Subject: Tyrone House Norton Lane Norton PO20 3NH - AL/2/21/DOC

Planning Application Reference: AL/2/21/DOC

Proposal: Approval of details reserved by condition imposed under ref AL/51/20/PL relating to Condition Nos 3 - materials & finishes, 5 - Energy Statement, 7 - car parking and 14 - external lighting

FIGURE 2 - PROPOSED EXTERNAL LIGHTING

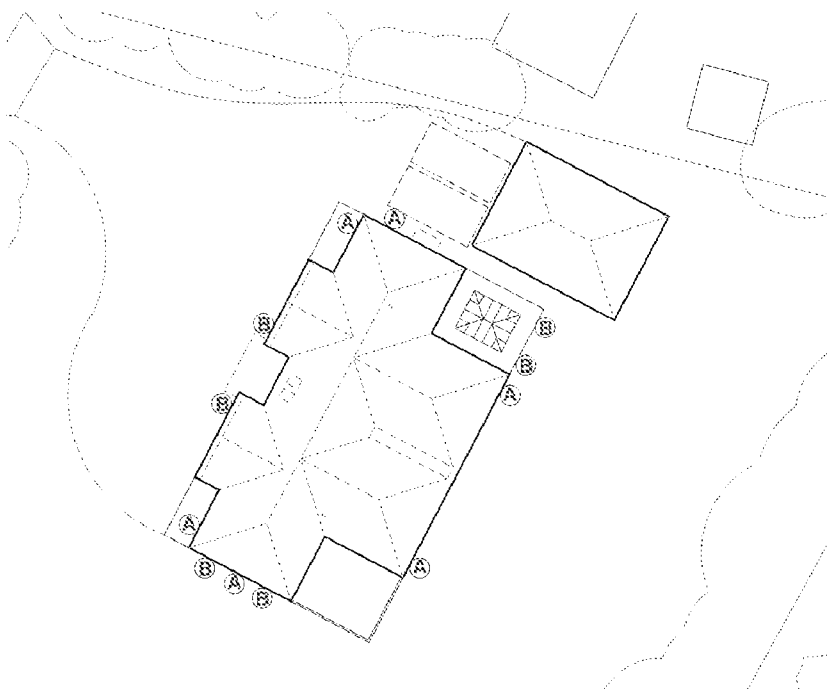
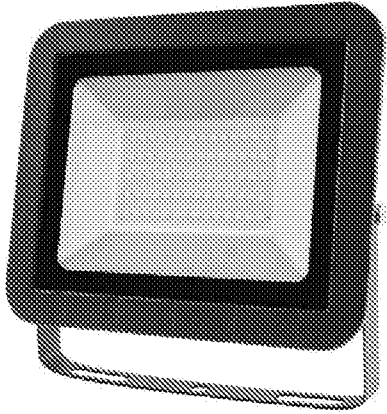
There is insufficient information to determine whether the proposed external lighting may potentially cause a light nuisance to neighbours. I note the proposed location of spot lights 'A', however a lux diagram showing the spot light orientation and extent of light spill is required to assess for potential light nuisance. I therefore recommend that the applicant be required to submit a lux diagram illustrating the orientation and extent of light spill from the proposed spot lights.

I therefore do not recommend discharge of condition 14 (external lighting) based on the submitted information.
